DRB Application No.: 09DRB-70341 Project # 1007690  
Project Name: ATLANTIC & PACIFIC ADDITION  
Agent: RHOMBUS CONSULTING Phone No.:

**M E M O**

**Re:** Project #1007690, 09EPC-40015 Sector Development Plan Map Amendment and  
09EPC-40016 SDP Building Permit - Working Classroom, Atlantic Ave. SW

SITE PLAN 1" = 10'

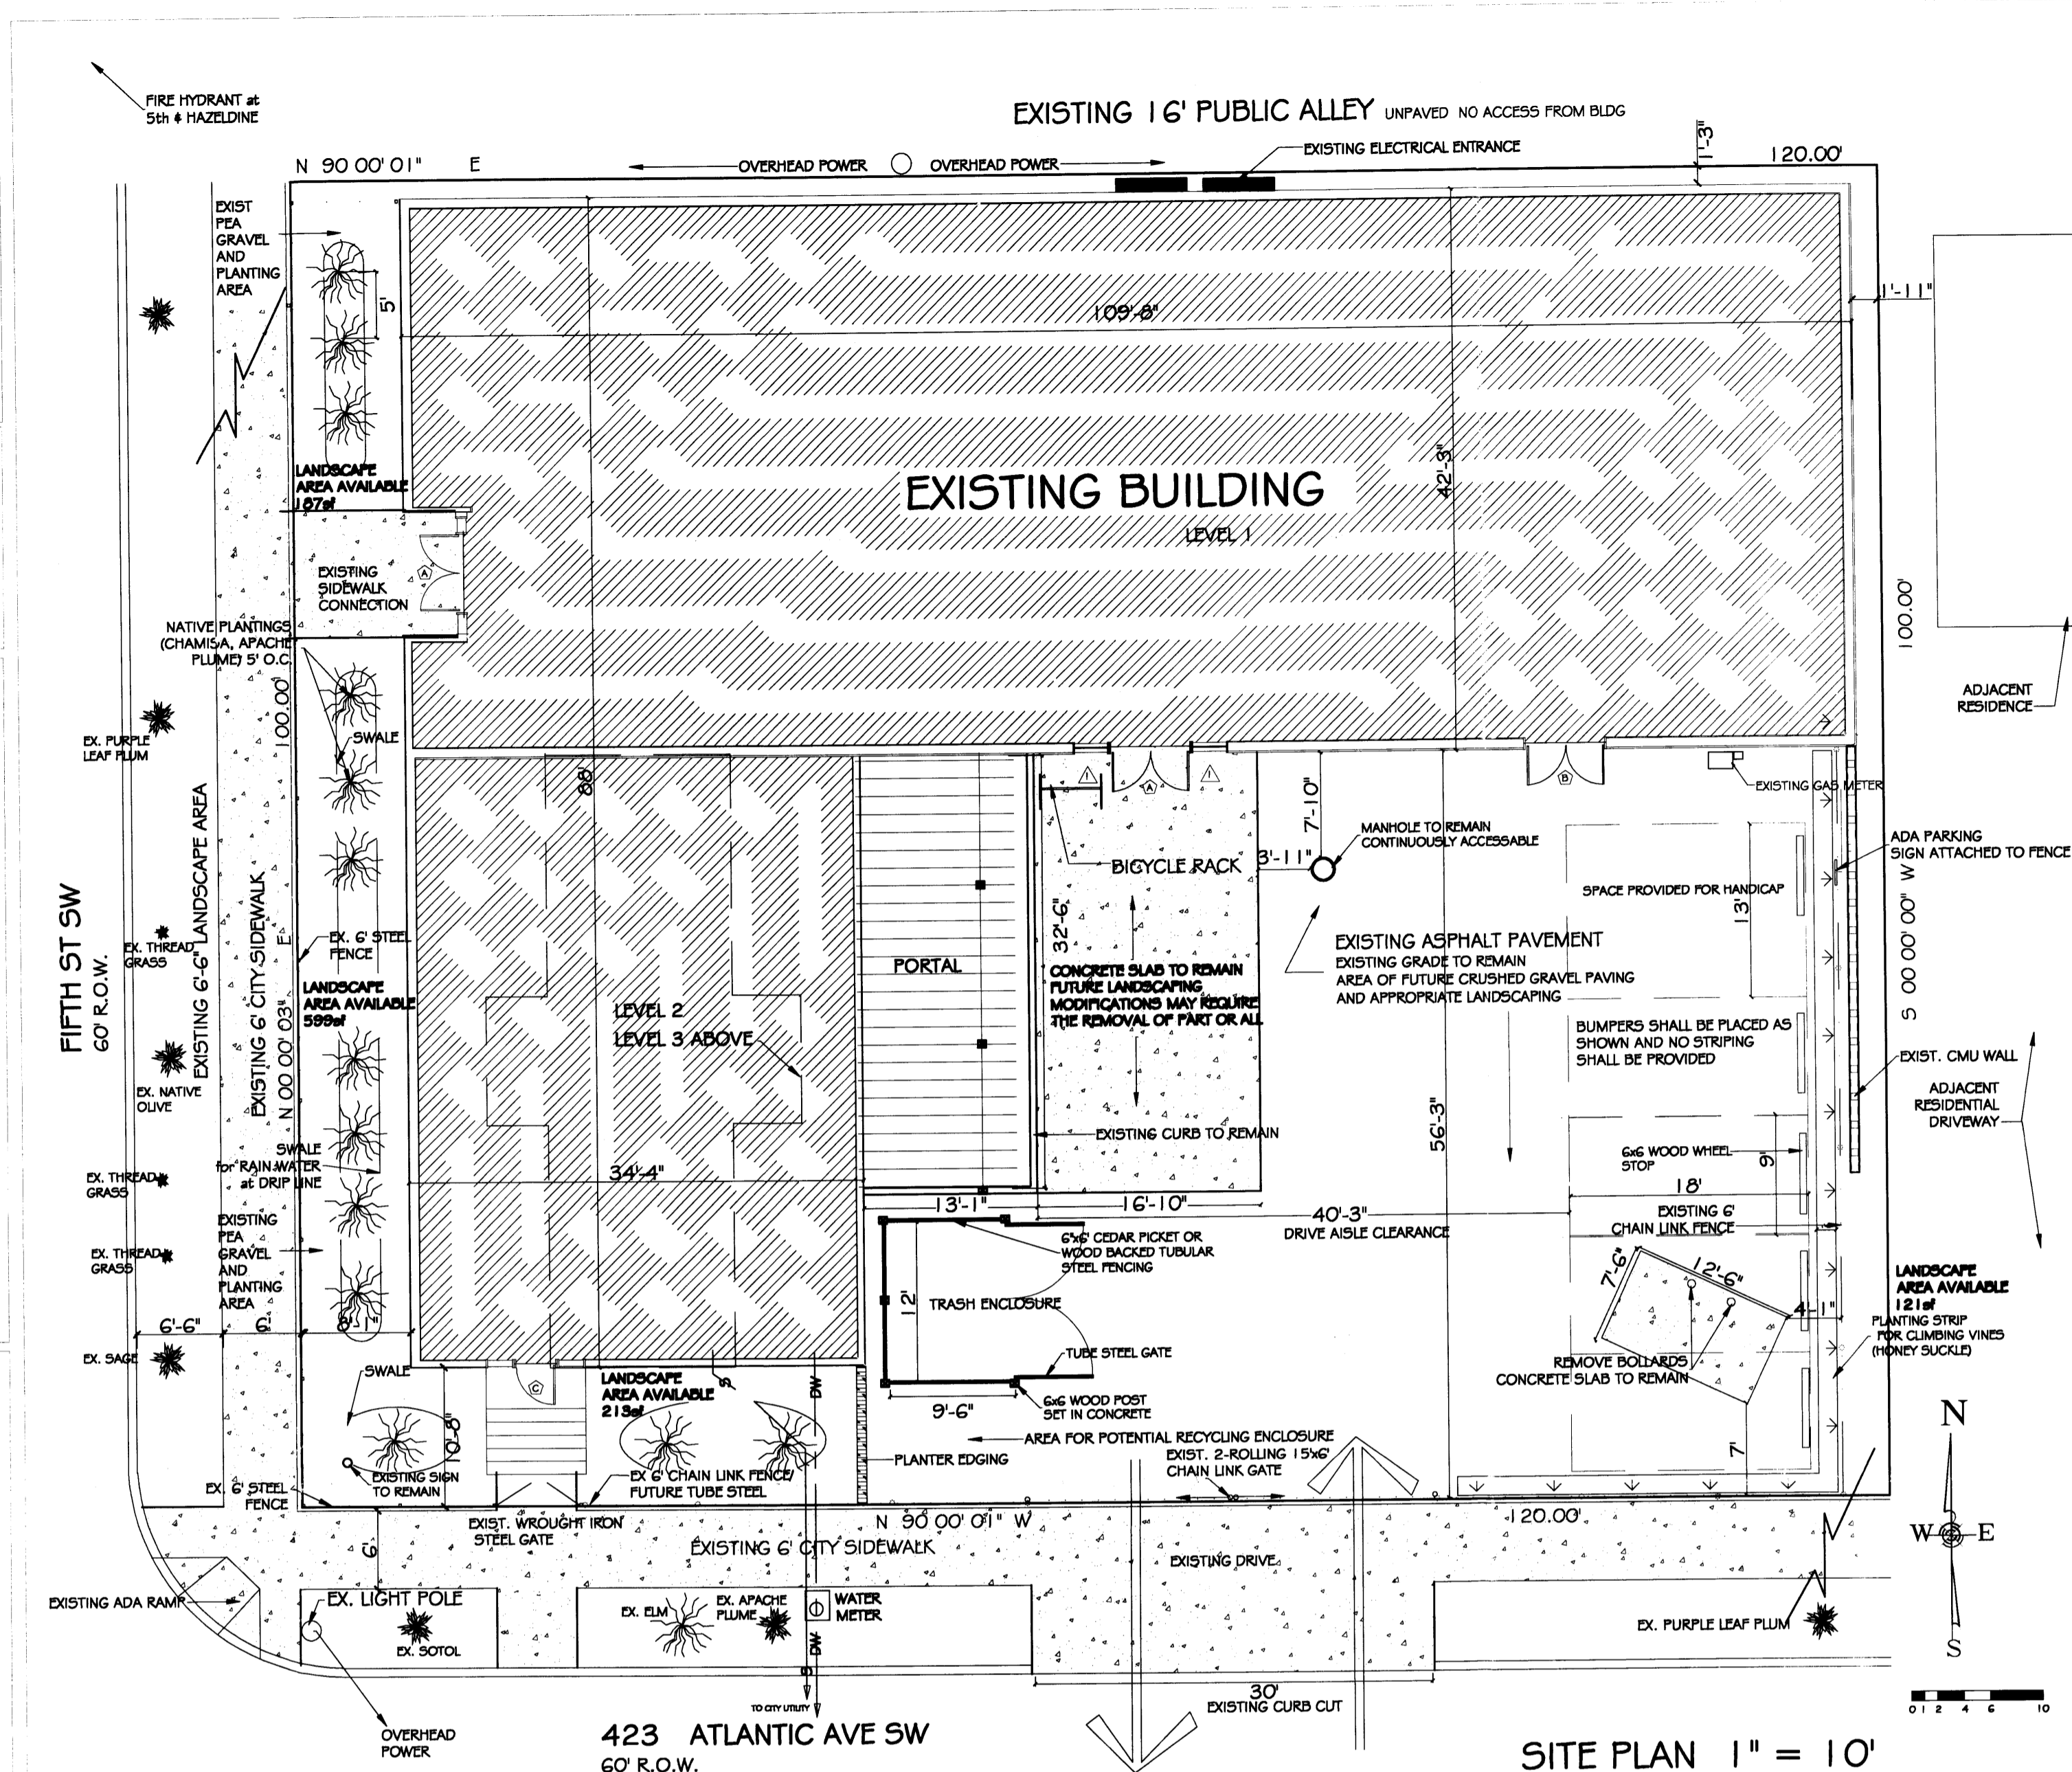
Approval of the site development was subject to 8 conditions. The staff planner delegates review of condition #4 to the DRB. The applicant satisfied the remaining conditions, but has the following comments on the future landscape palette:

- One medium water use ground cover and vine is acceptable (ref. #6.d).
- Change "desert sage" to a plant on the City Forester's or City Xeriscaping Guide such as "sand" or "big sage" or other low water use, evergreen species.
